**PUBLIC WORKS DEPARTMENT**  
Post Office Box 9010 Addison, Texas 75001-9010

# Memorandum

**To:** Carmen Moran  
**CC:** Nancy Cline  
**From:** Clay Barnett  
**Date:** 11/12/2008  
**Re:** Meridian Square

51 LOTS ~ 4.019 ACRES
FINAL PLAT
MERIDIAN SQUARE
A REPLAT OF
QUORUM EAST ADDITION
TOWN OF ADDISON
G.W. FISHER SURVEY ~ ABSTRACT NO. 482
DALLAS COUNTY, TEXAS
OCTOBER 2008 SCALE: 1"=30'
OWNERS
ADDISON URBAN DEVELOPMENT PARTNERS, LLC
500 W. LOOKOUT DRIVE
972-248-2147 RICHARDSON, TEXAS 75080
ENGINEER

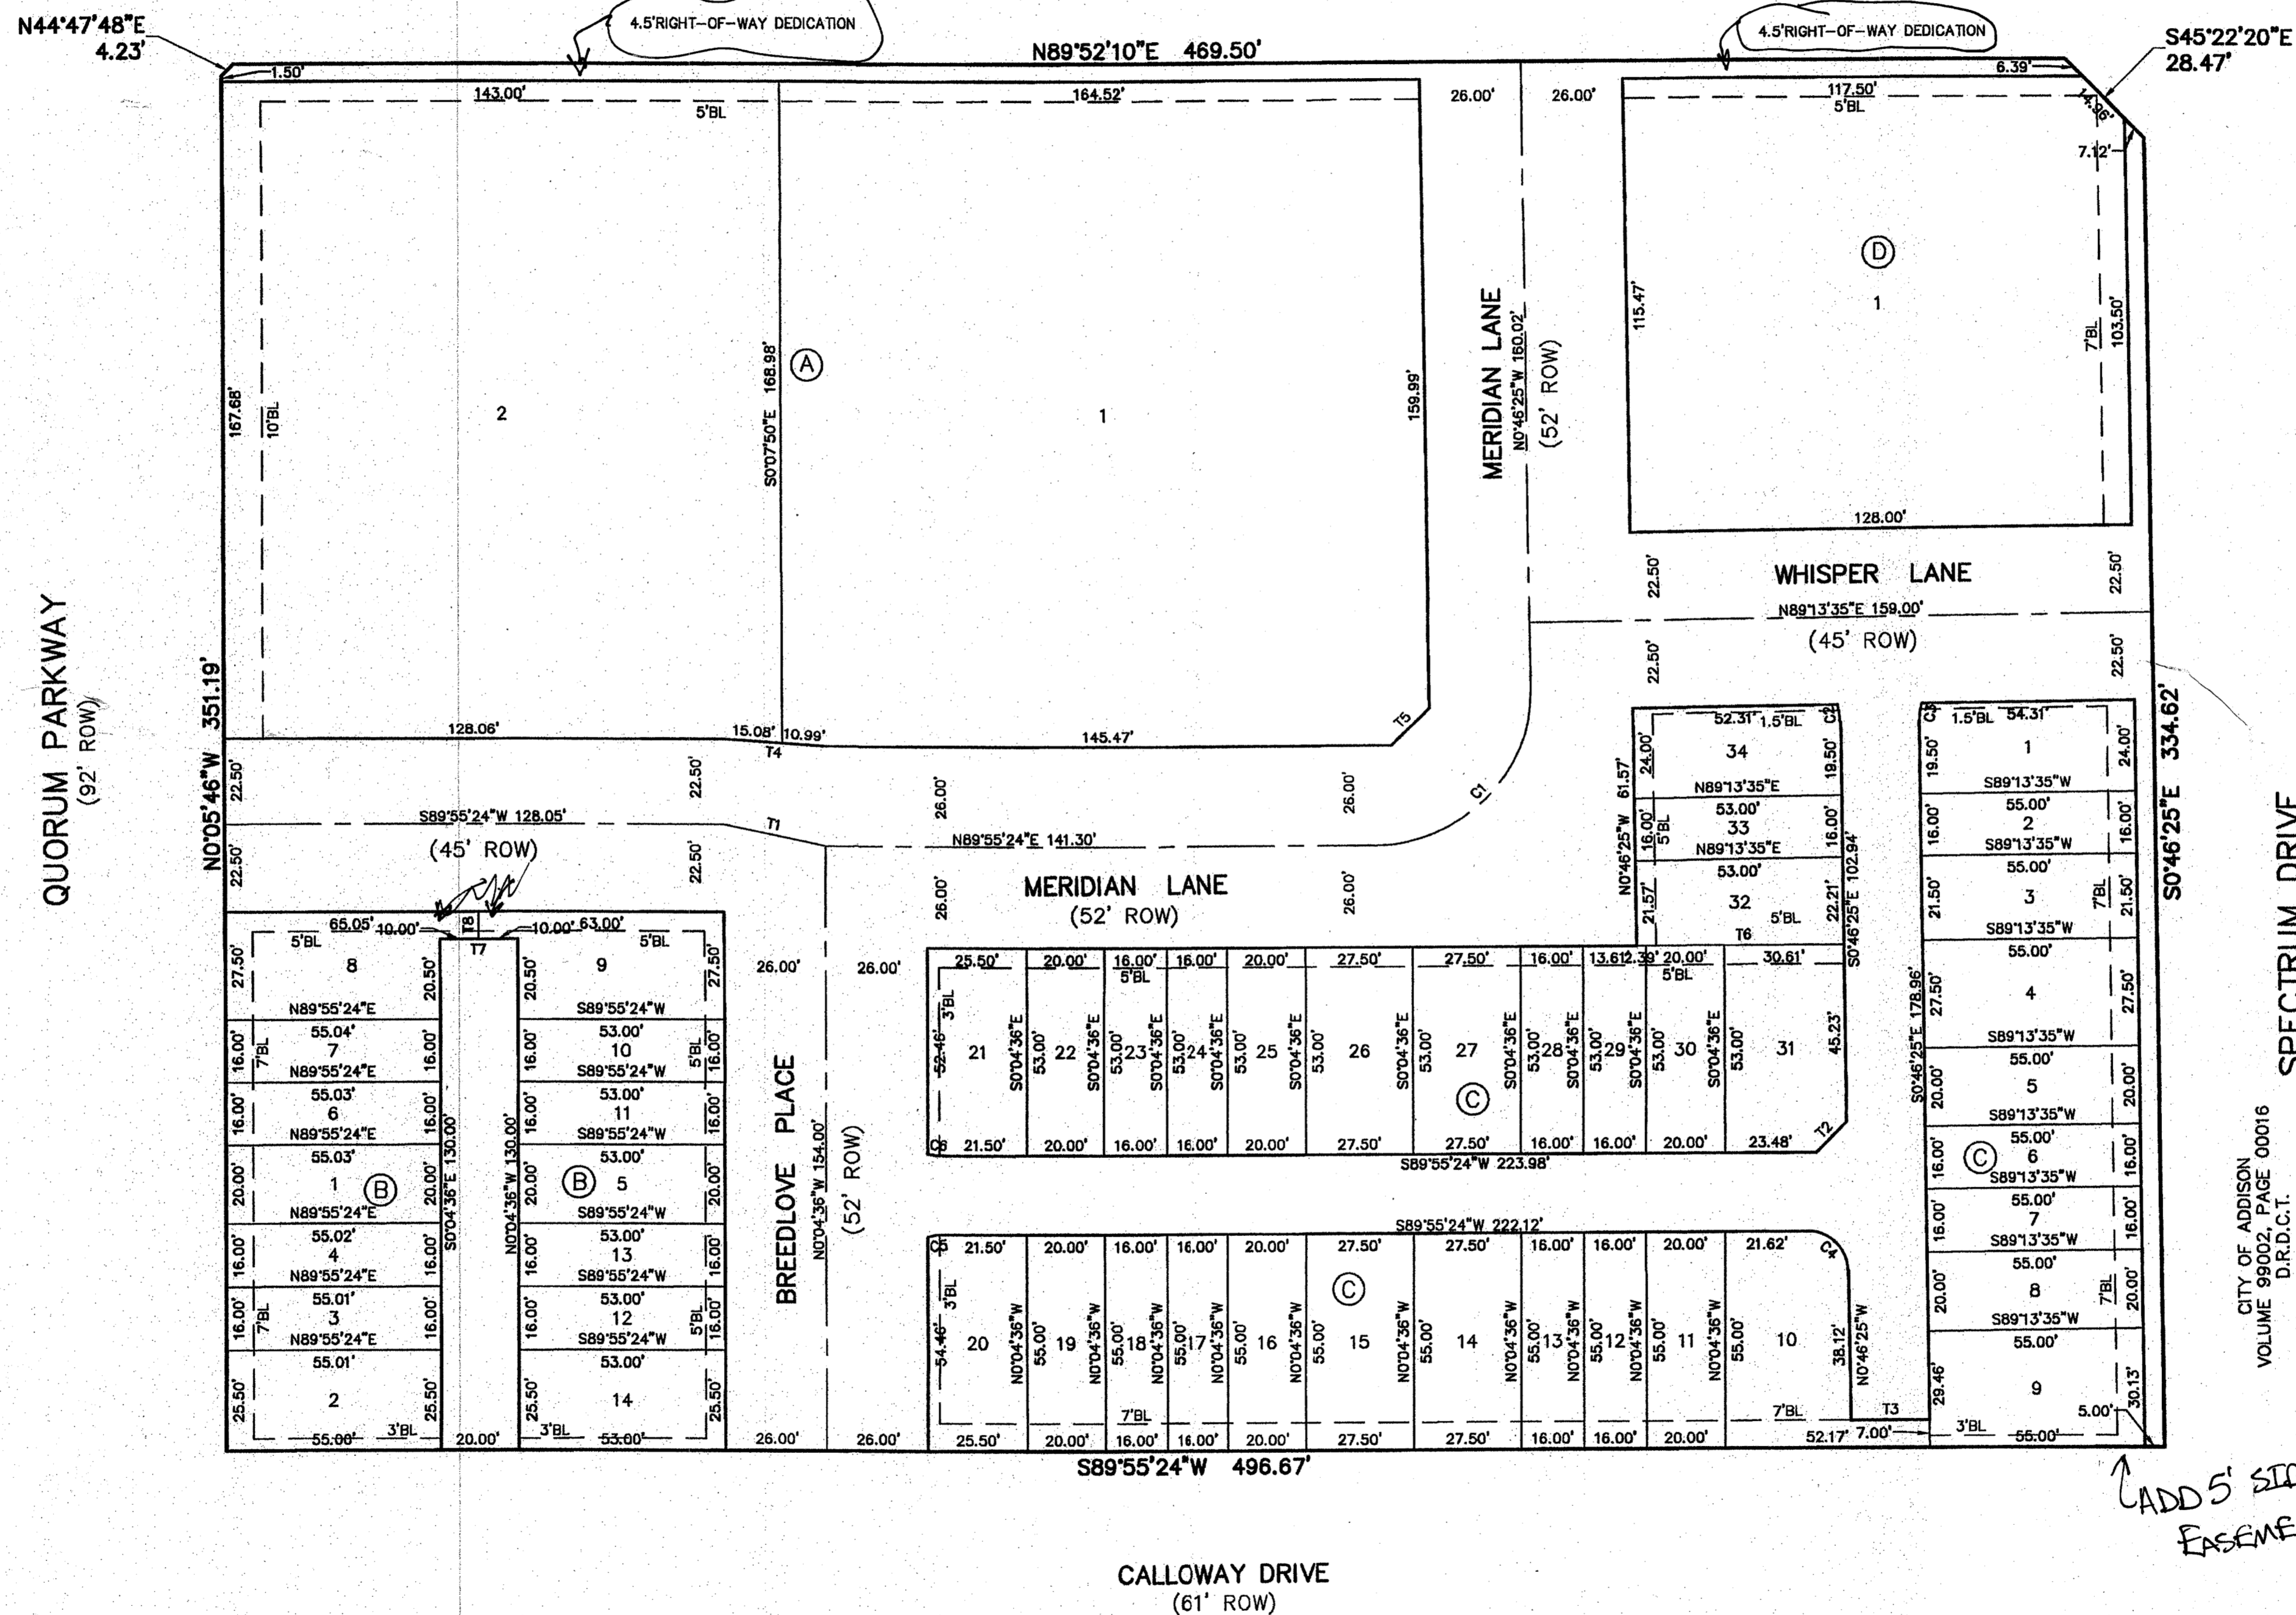
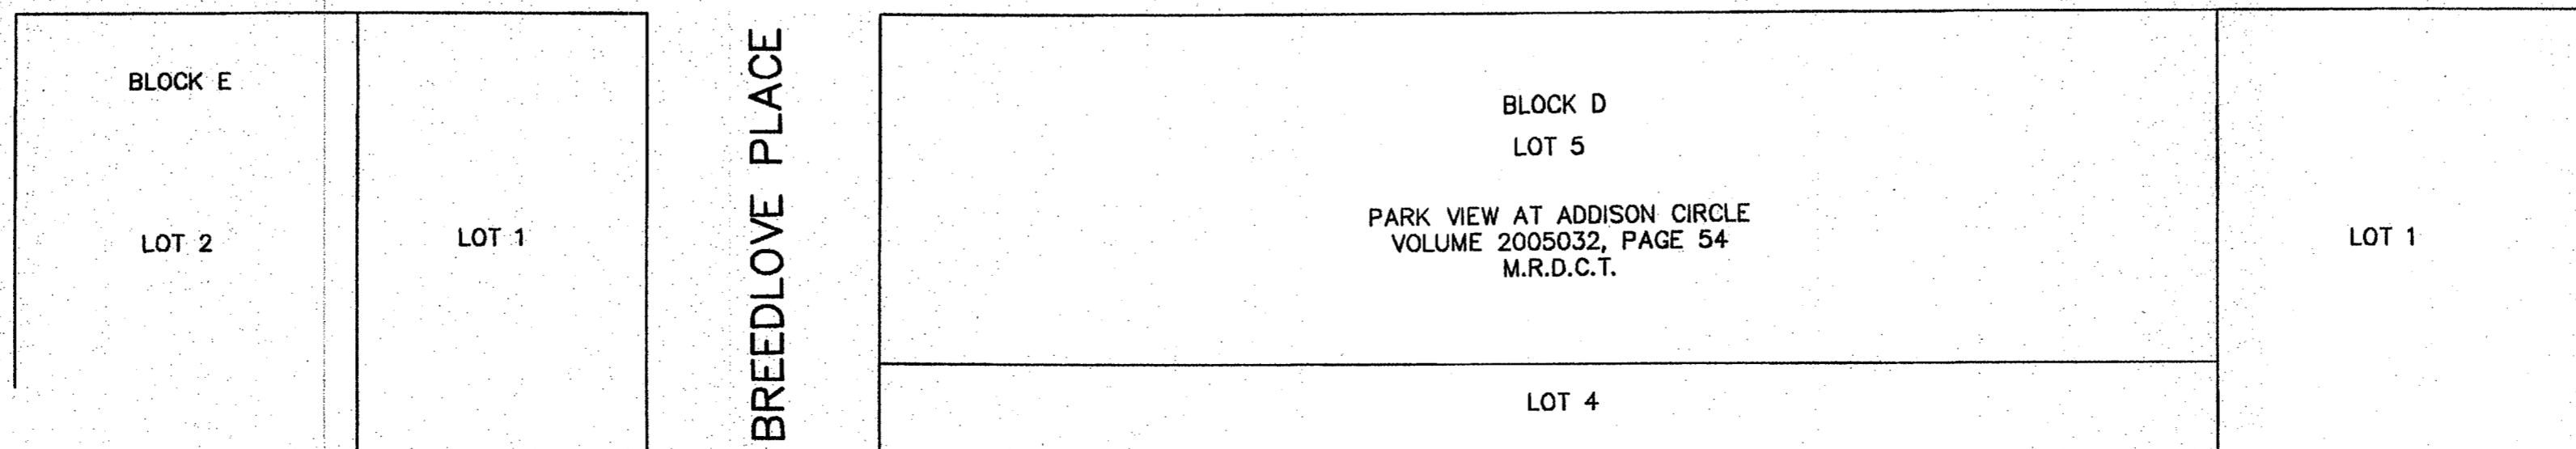
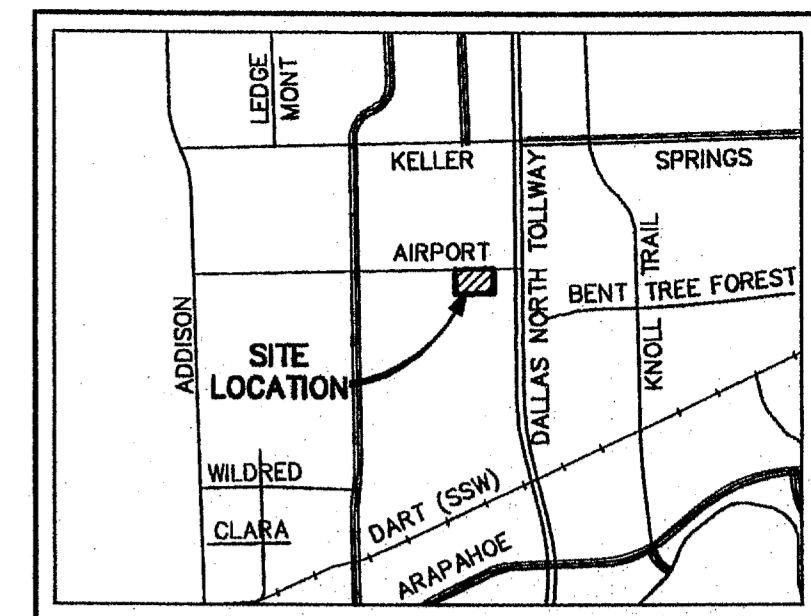
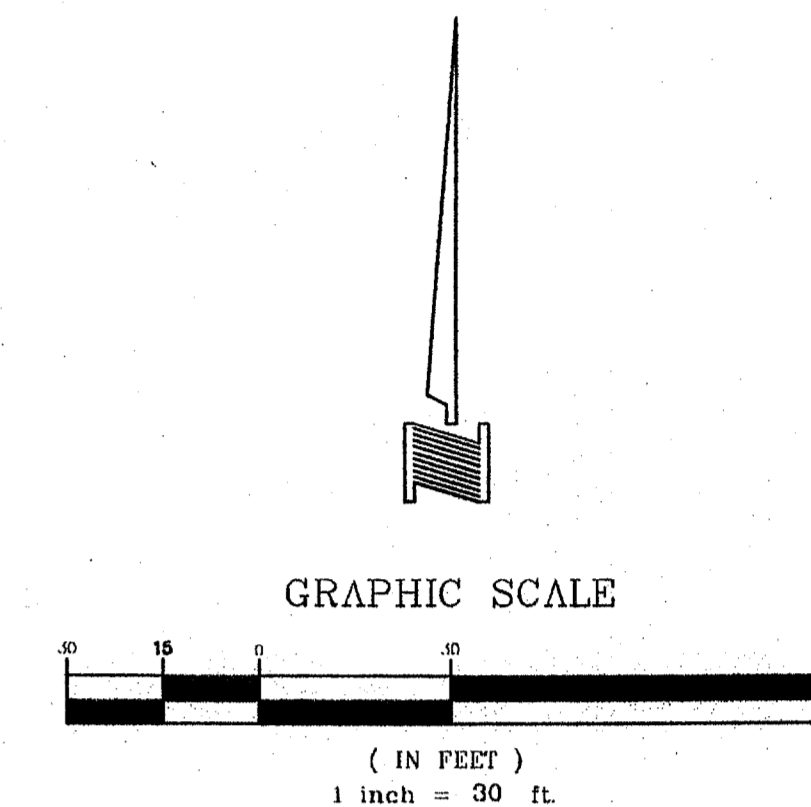
- 
1. Civil plans will need to be submitted for review and approval.
  2. Add a reference to the building line amendment to the UC Zoning to the face of the plat.
  3. Add center lines and the dimensions to the centerlines to the existing streets.
  4. Add a 5' Sidewalk Easement along the Spectrum Drive frontage.
  5. Revise the Dedication Statement as required to match the Dedication Statement given in the Town of Addison Code of Ordinances.
  6. Will a 5' Utility Easement along the alleys be needed? If so, please add.
  7. Add the POINT OF BEGINNING to the face of the plat.
  8. Provide a closure sheet.
